12 Highroyd, Lepton, Huddersfield
Planning Application

Your Ref: 2022/62/93686/W
Our Ref: Y013973

12, Highroyd, Lepton, Huddersfield - Demolition of existing conservatory and erection of single and two storey side and rear extension

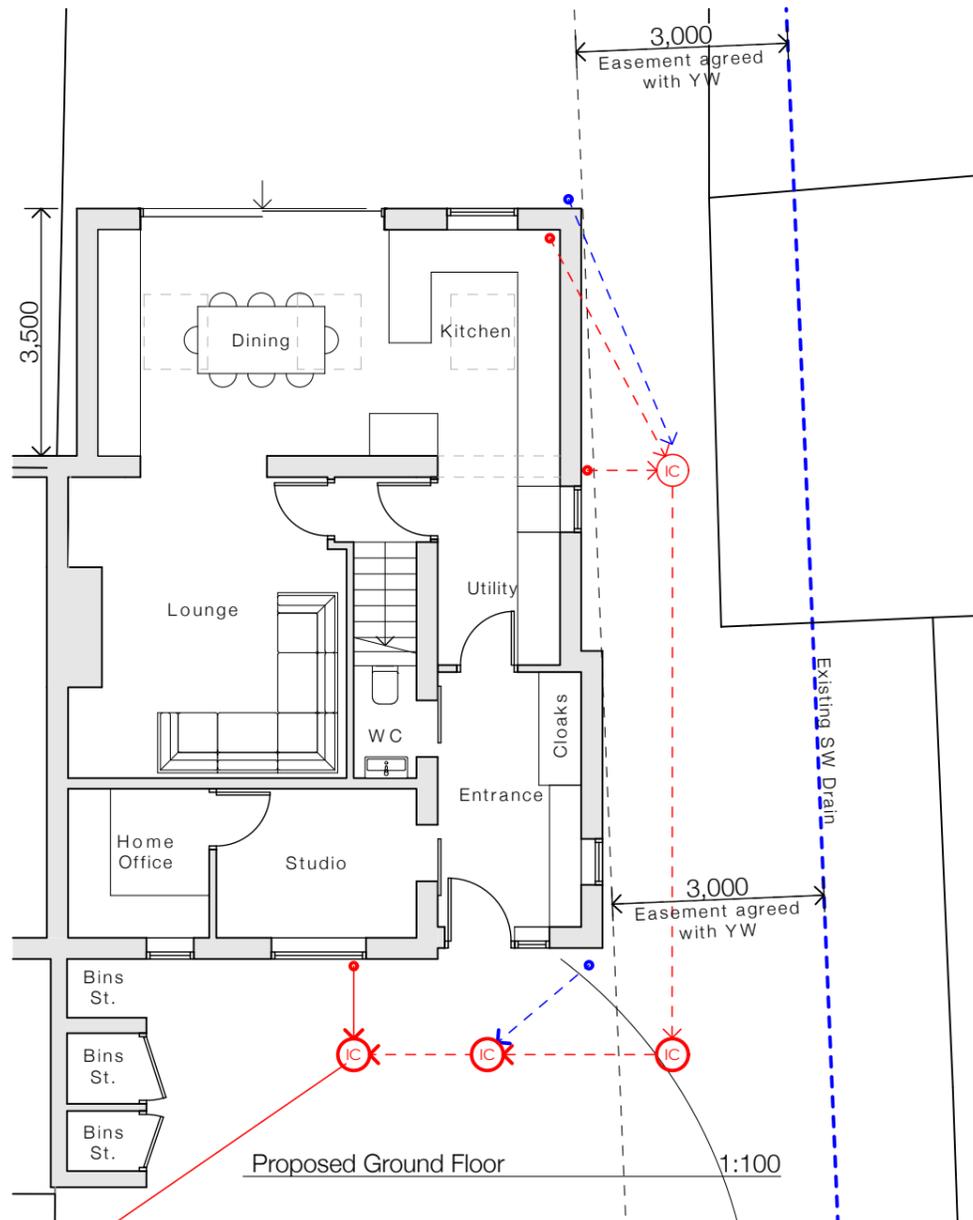
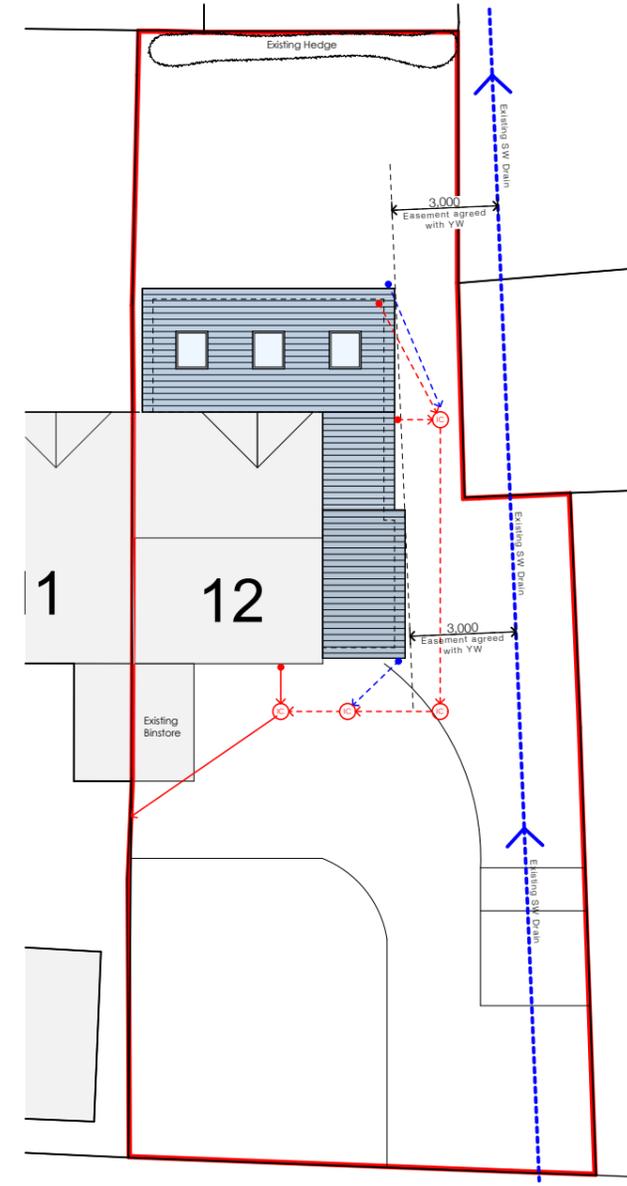
1.) Yorkshire Water has no objection in principle to the drainage details submitted on drawing 'Proposed Plans and Elevations' 0110/2017-05 dated October 22, namely: -

a.) The proposed building stand-off from public sewer centre-line (of three metres)

2.) On the Statutory Sewer Map, there is a 450 mm diameter public surface water sewer recorded to cross the site. It is essential that the presence of this infrastructure is taken into account in the design of the scheme.

a.) It may not be acceptable to raise or lower ground levels over the sewer and we will not accept any inspection chambers on the sewer to be built over.

b.) In this instance, a stand-off distance of 3 (three) metres is required at each side of the sewer centre-line and it may not be acceptable to raise or lower ground levels over the sewer, nor to restrict access to the manholes on the sewer.
